Subject: RE: White Lodge Rectory Lane Angmering - A/207/16/HH and A/208/16/L

I have substituted the submitted plans for the originals and have discussed the revised plans with Dr Wightman. The design of the actual extension is now acceptable. His only remaining concern is the amount of wall being removed on the ground floor, especially under the beam.

Ground Floor Plan
as existing

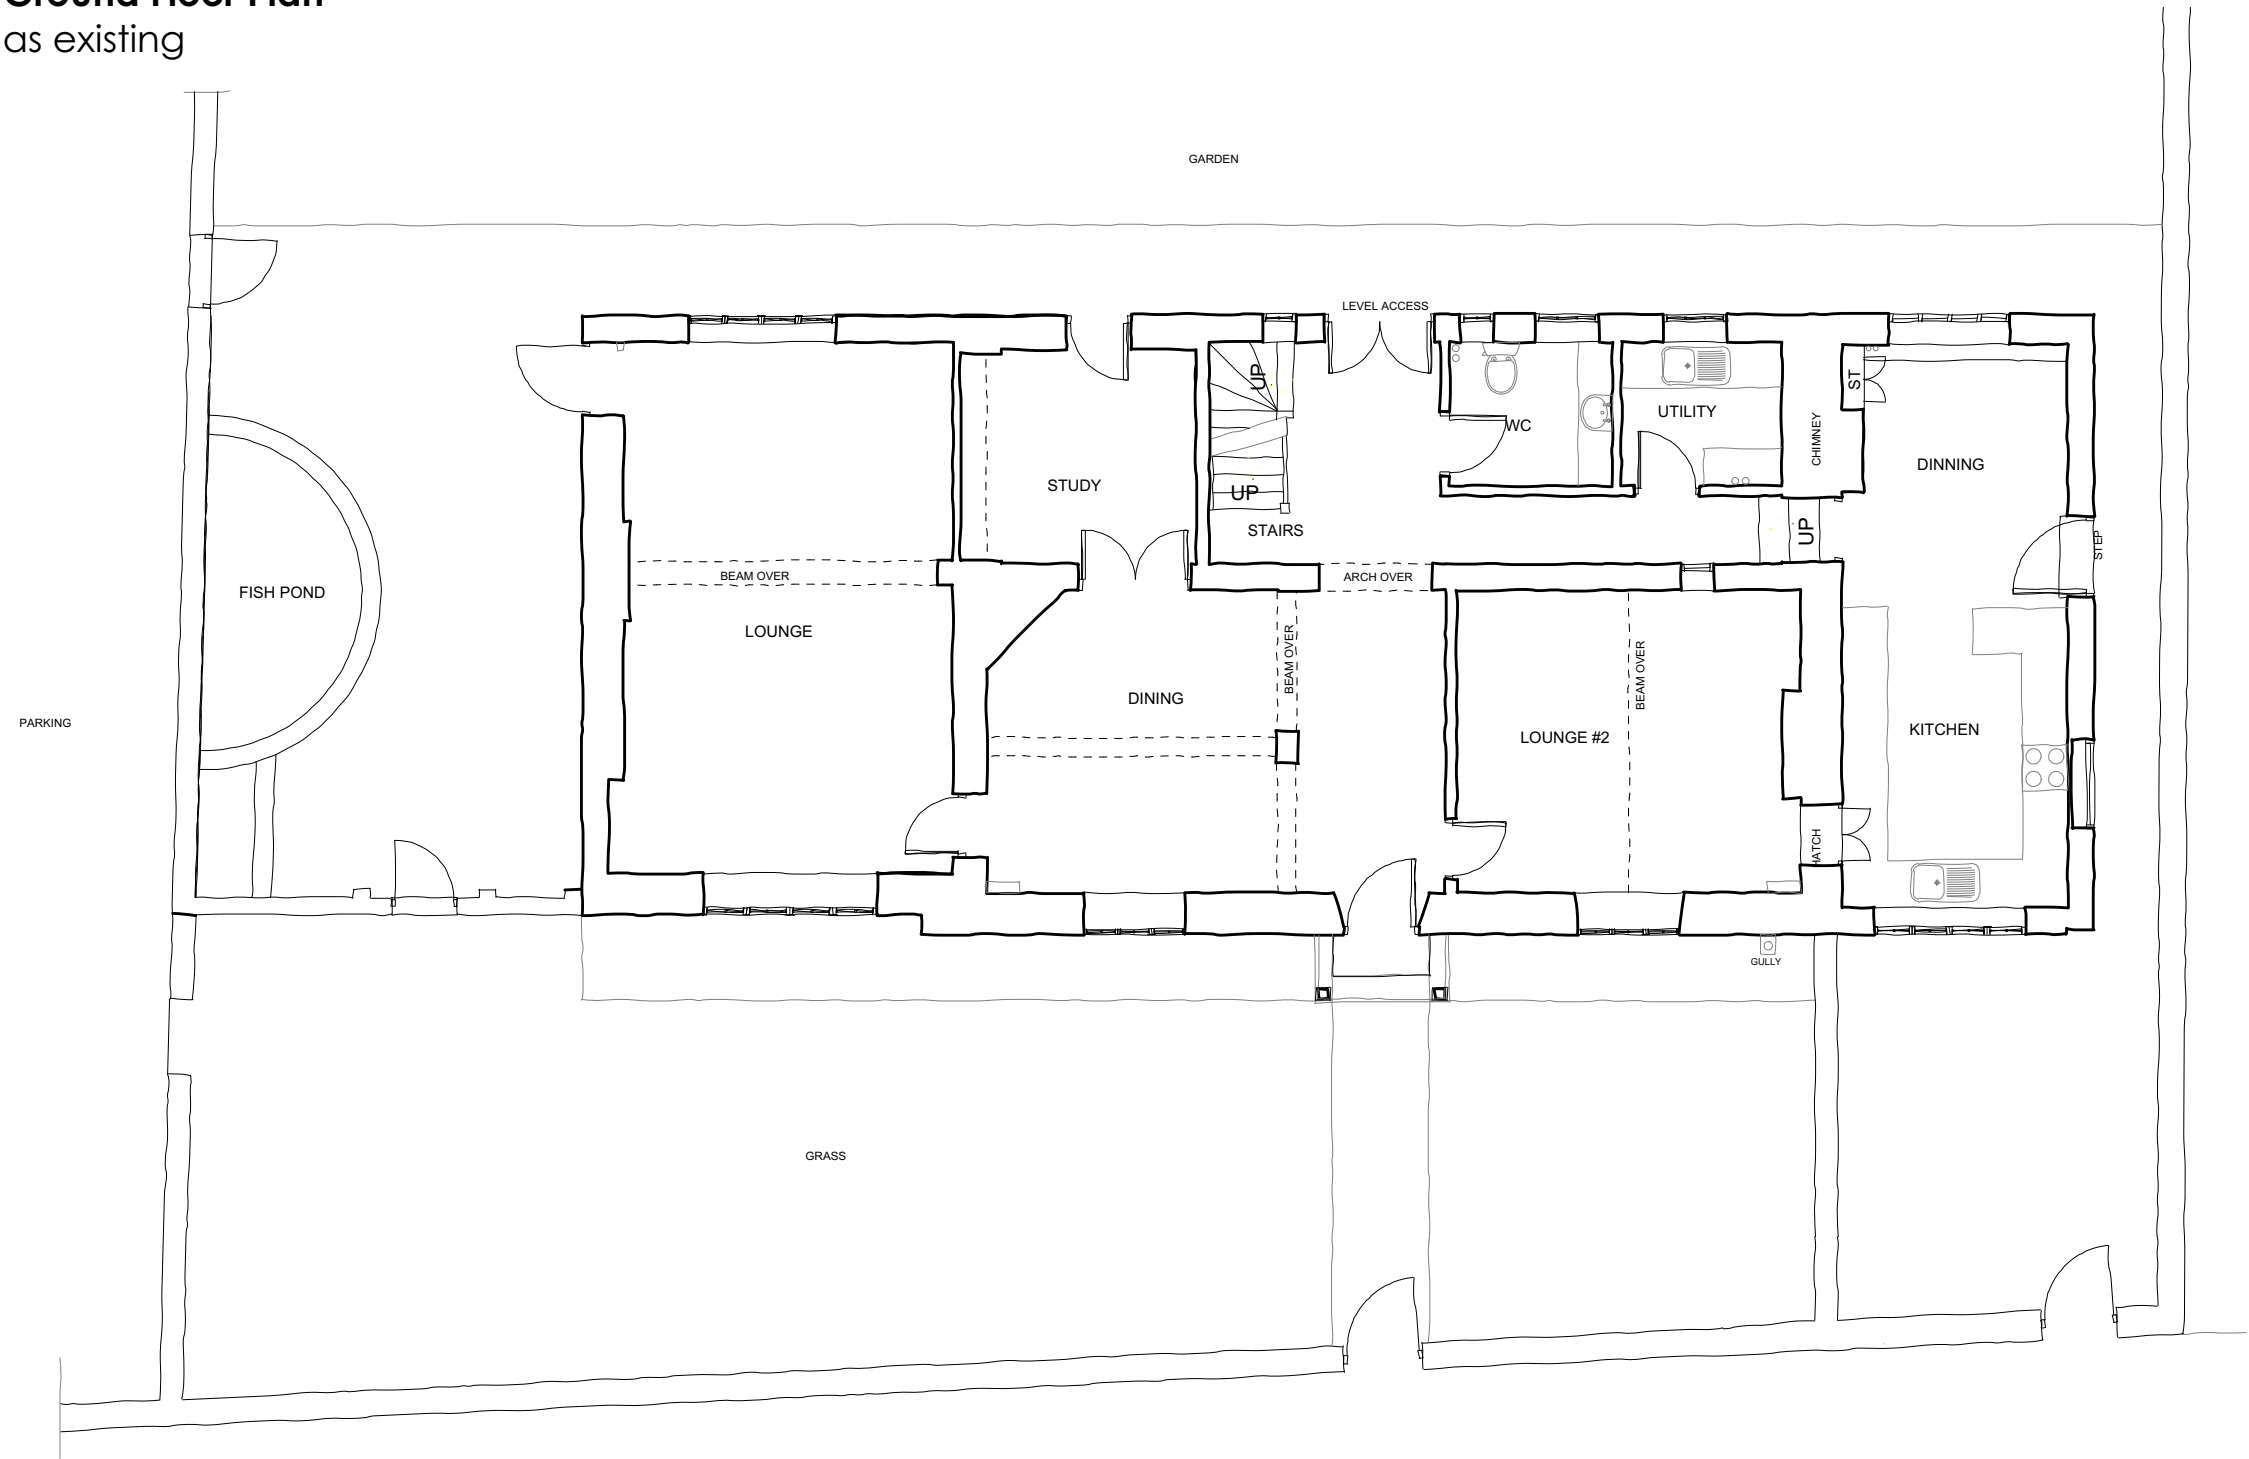
He would rather see the ground floor layout plan amended to retain the side wall of the dwelling up to the limit of the family room with only the dining area open to the kitchen.

Without prejudice I would appreciate receipt of an amended floor plan to detail this area of walling retained .

This final element of contention, and one on which we are struggling to see any merit in the Conservation Officer's view, is in the request to close down the width of the opening in the Victorian wall, which will be entirely internal. We have already ensured, through stepping back the wall lines externally, leaving very substantial nibs and by the necessity of a down stand internally, that the original external wall will be legible as such. The fabric which will be lost is of no historic value. This coupled with it being entirely within our home, not a visible change to the public realm, and in the least sensitive part of the building, make insistence upon such a reduction appear without warrant. It would also fundamentally restrict the function of the space which we are seeking to add here, so as to remove the need for any alterations in more sensitive areas.
